From: Laura Gibbons
Sent: 03 May 2019 16:02
To: Simon Davis <Simon.Davis@arun.gov.uk>
Subject: RE: Y/9818/RES and Y/97/18/DOC

Still not happy with the details or the proposed landscaping details. My original comments are shown in blue, the applicants responses are provided in red, and my responses to these are shown in *purple*:

Comments on the revised drainage and landscape proposals:

BOVIS HOMES
scheme: Land off Burndell Road Yapton
client: Bovis Homes
drawing: Hard Landscape Proposals
date: Nov. 2018
scale: 1:200@A1
drawing no: BOV22172 12E sheet 4
drawn: AE checked: DKM

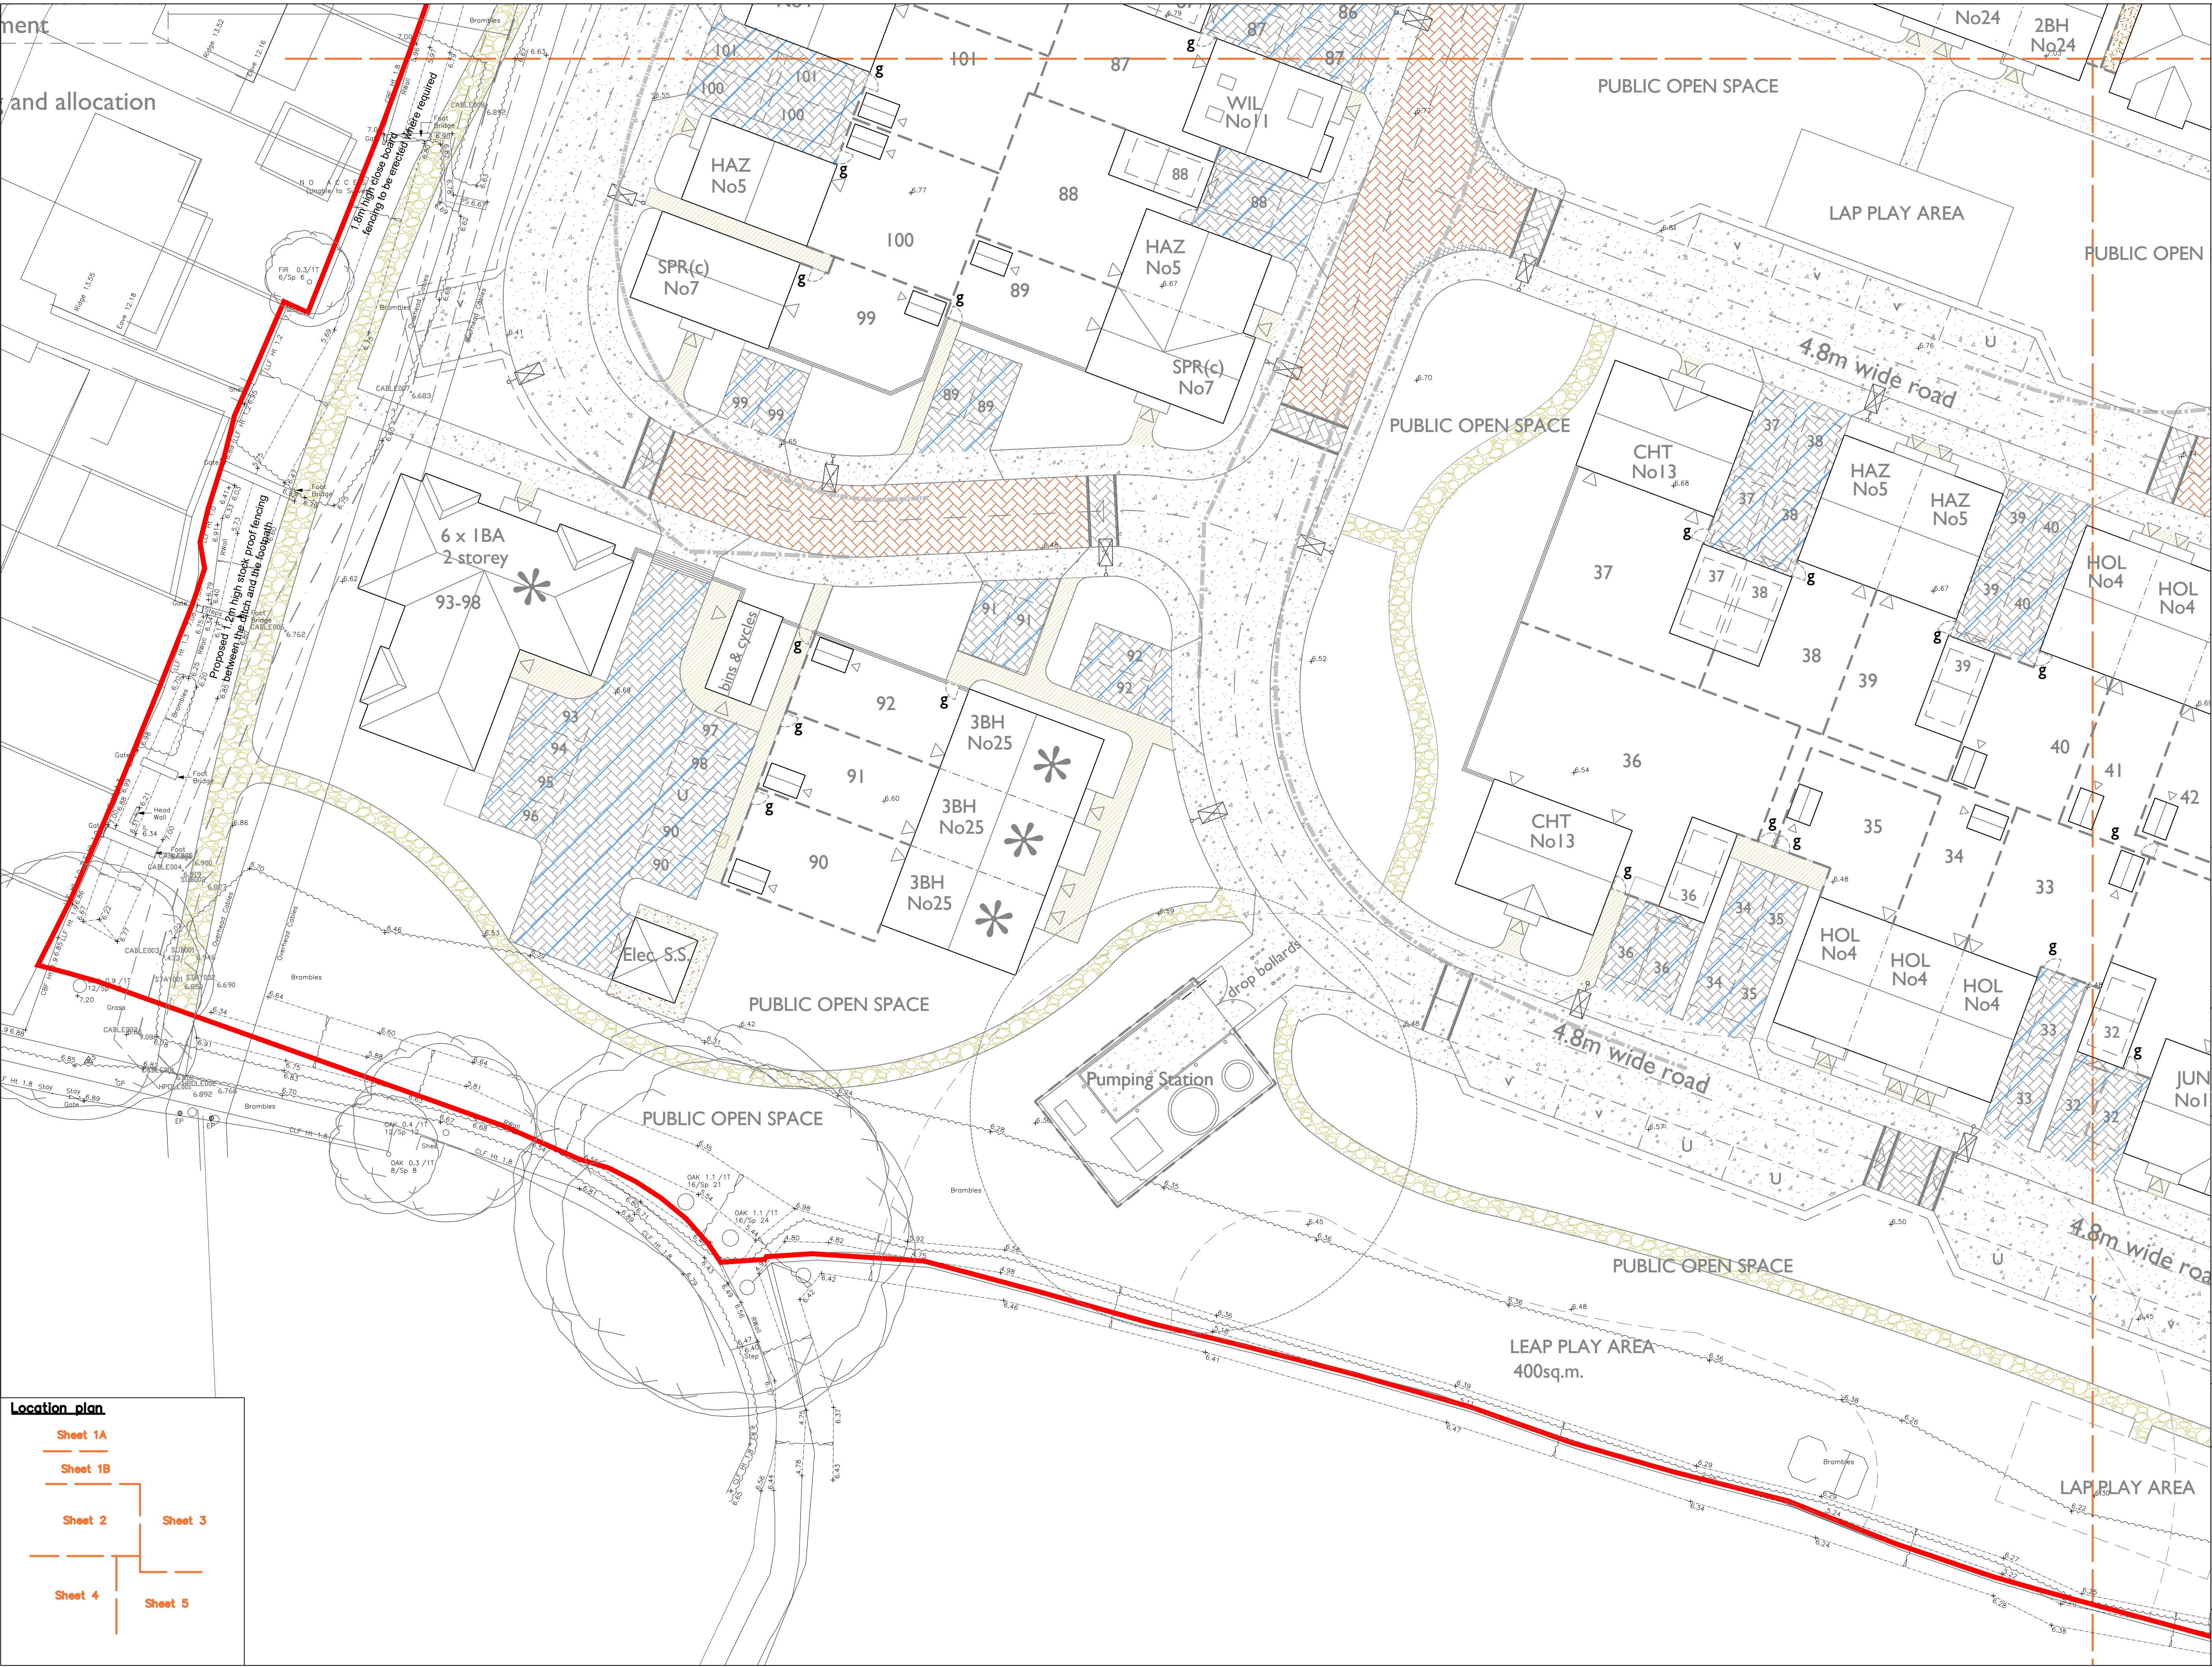
1. There are still trees proposed in close proximity to the southern-most attenuation tank. 2 no. trees close to this tank have been removed. Refer to updated ACD landscaping drawings. *On the ACD landscape drawing sheet 4 revision G there are trees in close proximity to the crate nearest the pumping station. Please can a plan be provided which shows both the proposed drainage and the proposed planting and associated potential root areas on the same drawing.*

Job Title		
LAND SOUTH OF BURNDELL ROAD, YAPTON		
Drawing Title		
PRIVATE DRAINAGE CONSTRUCTION DETAILS SHEET 1 OF 2		
Client		
BOVIS HOMES		
Scale	Date	Designed
NTS @ A1	APR 19	SG
Drawn	Checked	Approved
TSB	SG	LH
Job No	Drawing No	Rev
18-070	18-070/110	C

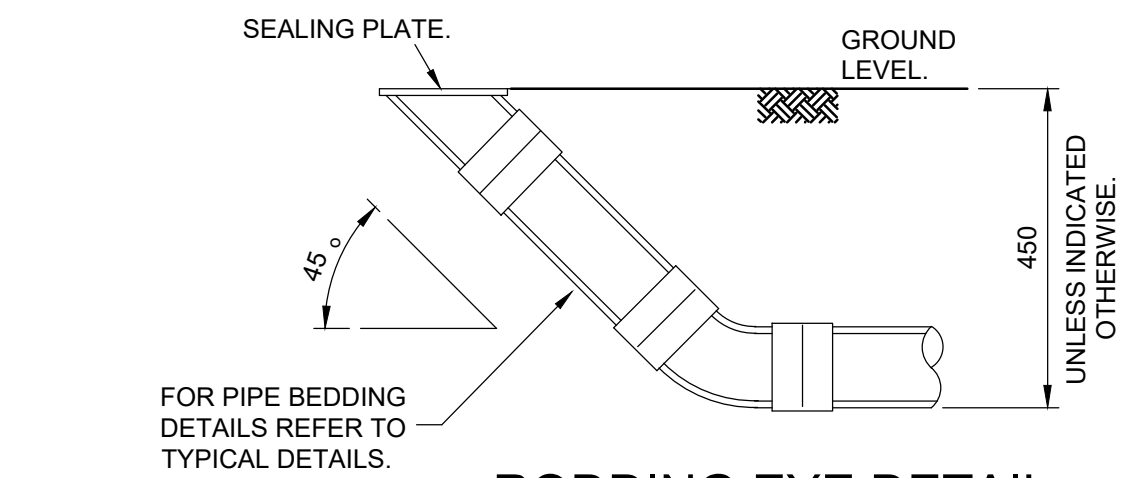
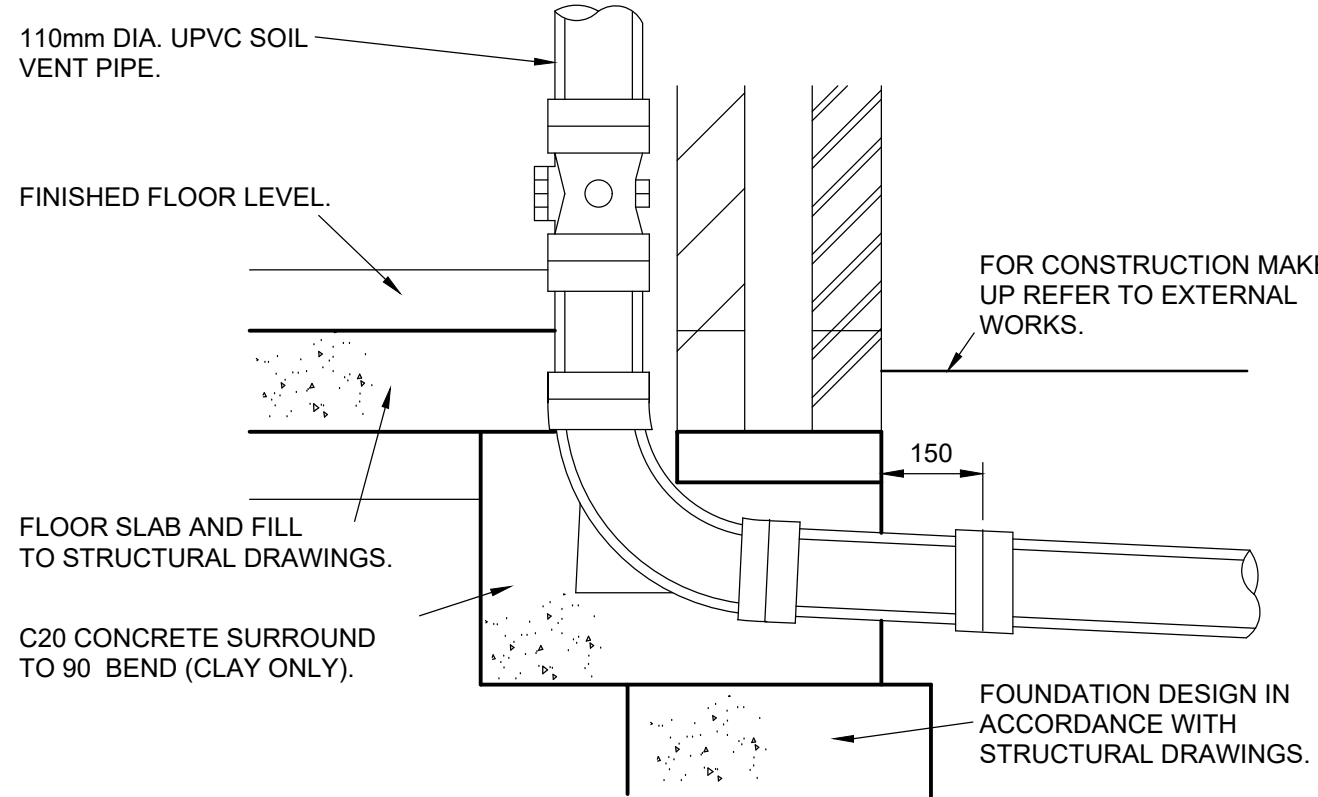
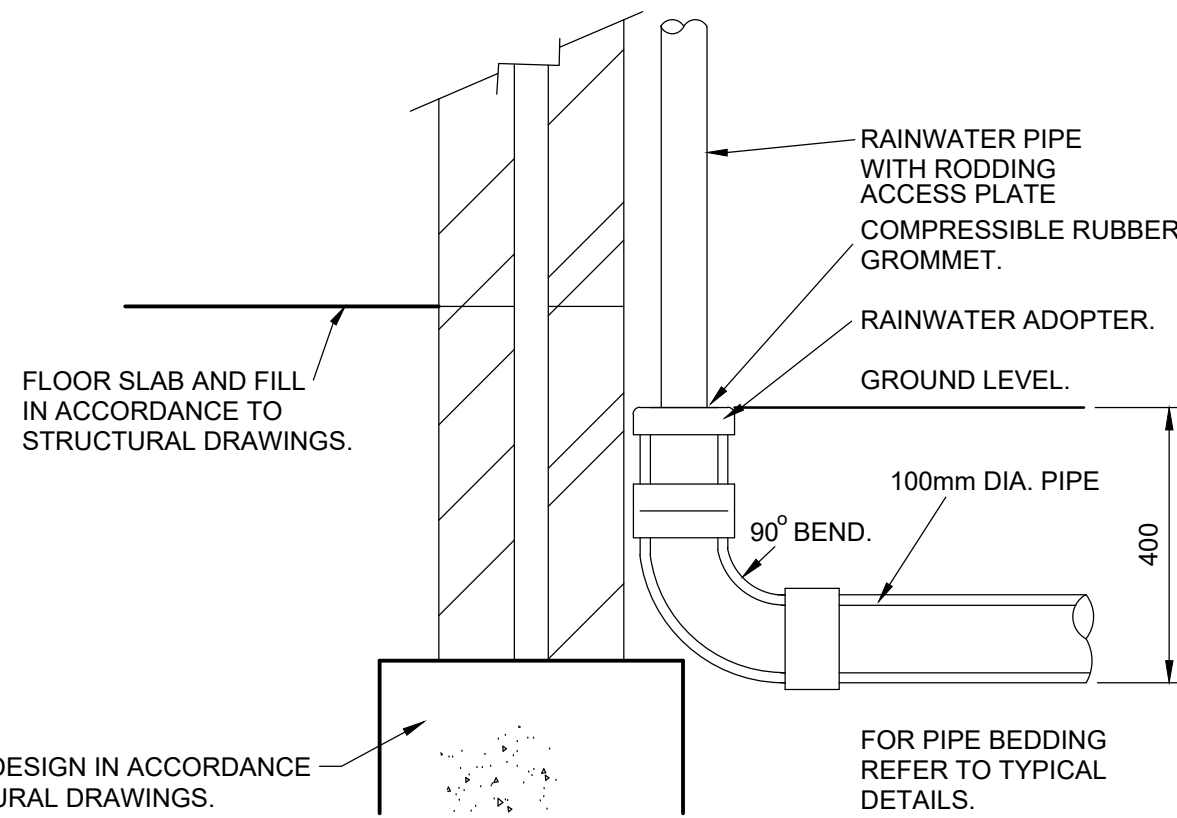
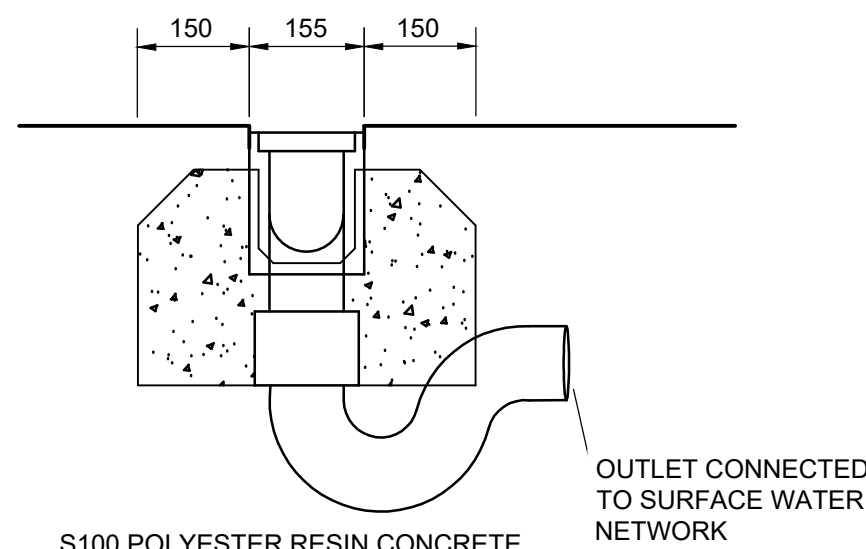
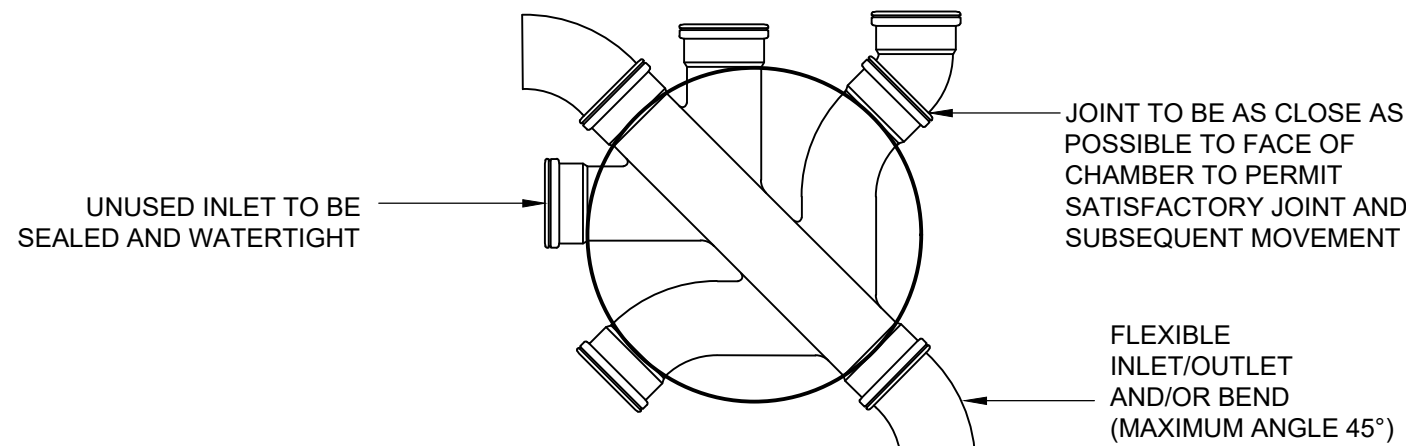
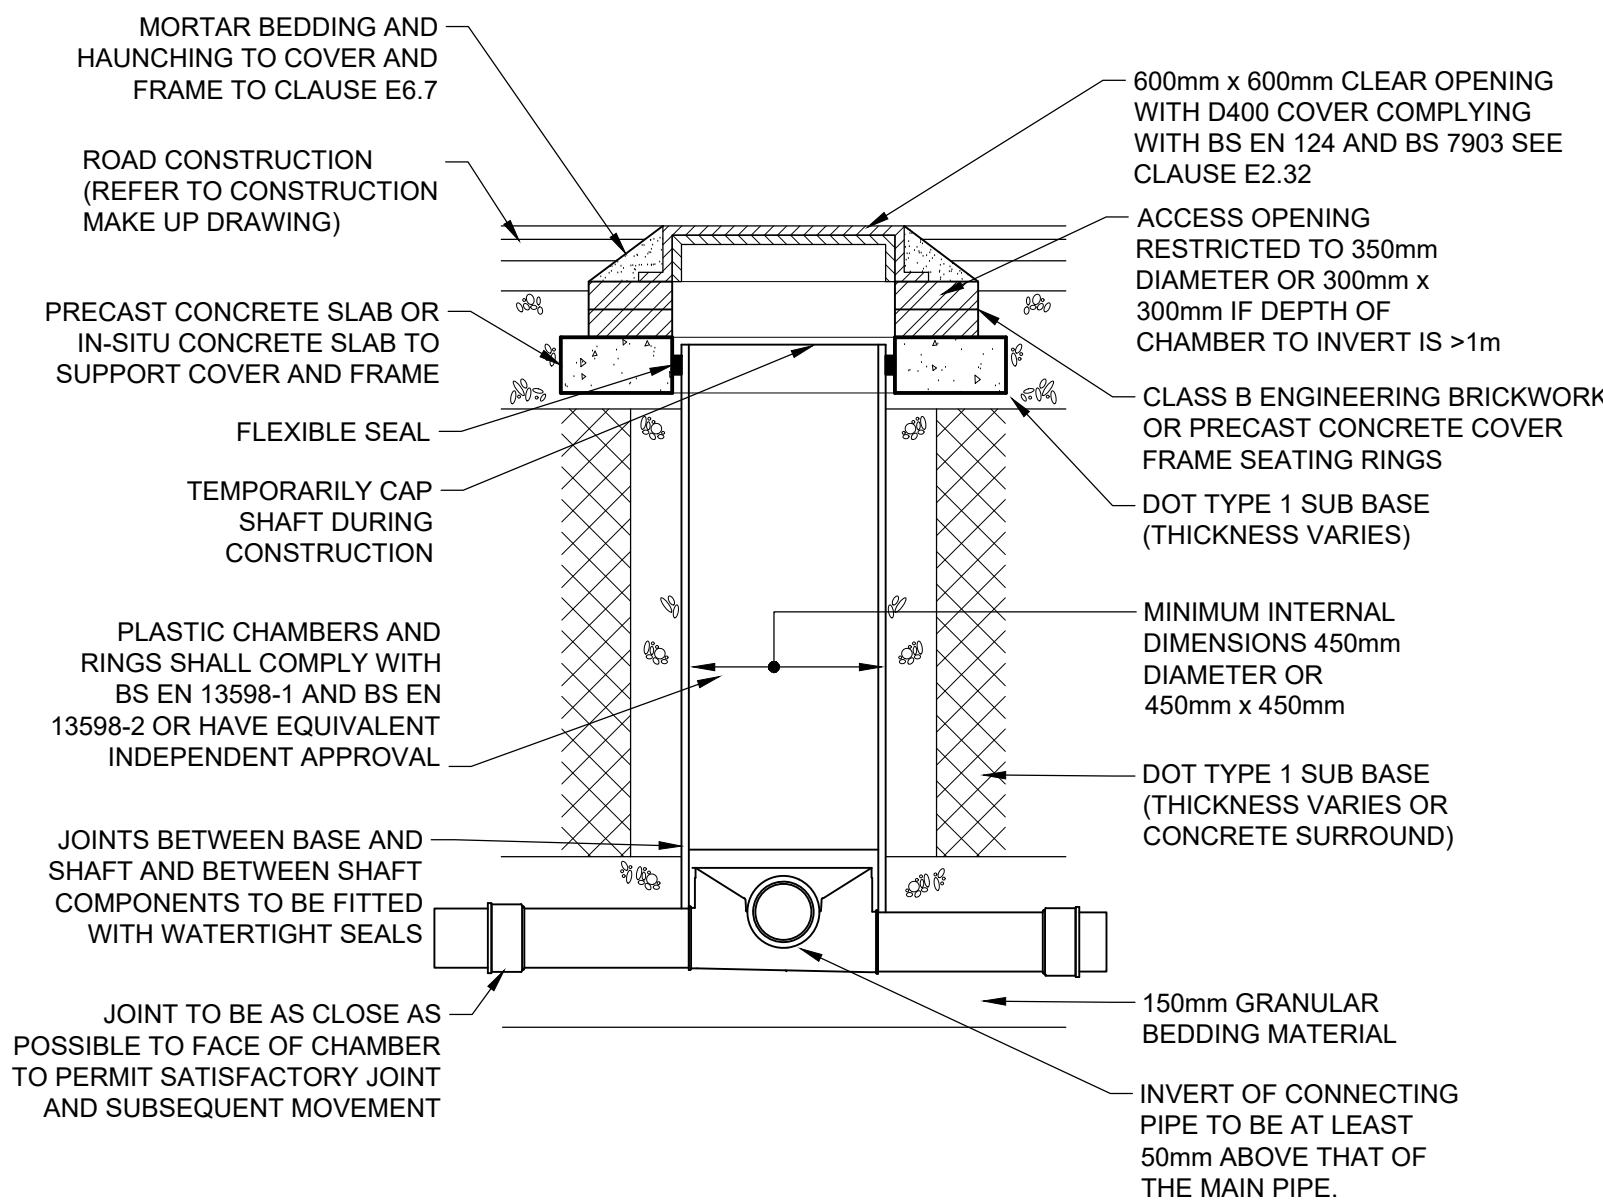
- a. *Construction detail drawings have been provided of diffuser units stating inlet from house, is this what is proposed? It isn't actually clear from the layouts if standard rwp connecting to the main piped network are proposed. There certainly are no diffuser units shown on layouts.*

7. Construction detail drawings need to be provided. I recommend that the applicant refers to our checklist for further detail of our requirements. Construction details provided. *Construction details of tanks, ponds and outfalls need to be provided.*
